Demolition of existing house & erection of 3x 3 bedroom houses together with landscaping, car parking and fencing.

Gladwyn The Street East Preston

Thank you for your internet representation made on 30th January 2019 which has been recorded as '**an objection**' with the comments as follows:

Drawing: Street scene

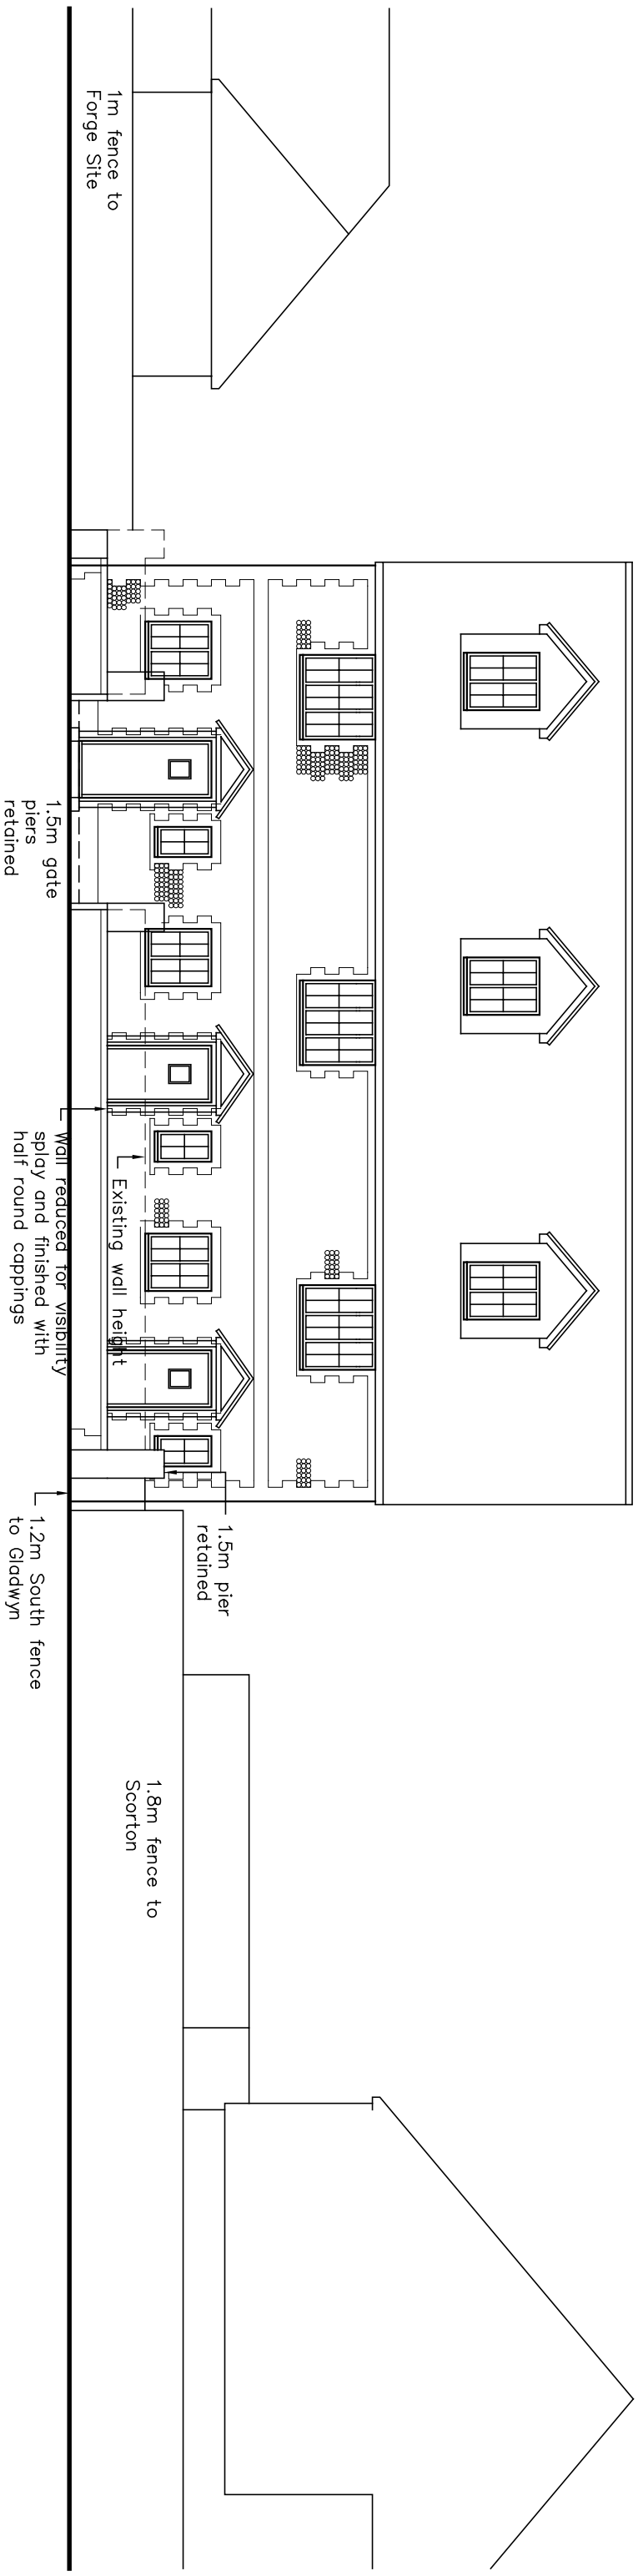
The design of the three proposed houses is not appropriate for their position, opposite three listed cottages. and is of disappointing quality. The appearance of the proposed houses should be more cottage-like, to harmonise with their surroundings and especially the adjoining listed buildings. The large dormer windows, extending to the edge of the roof, are an especially inappropriate feature of the design.
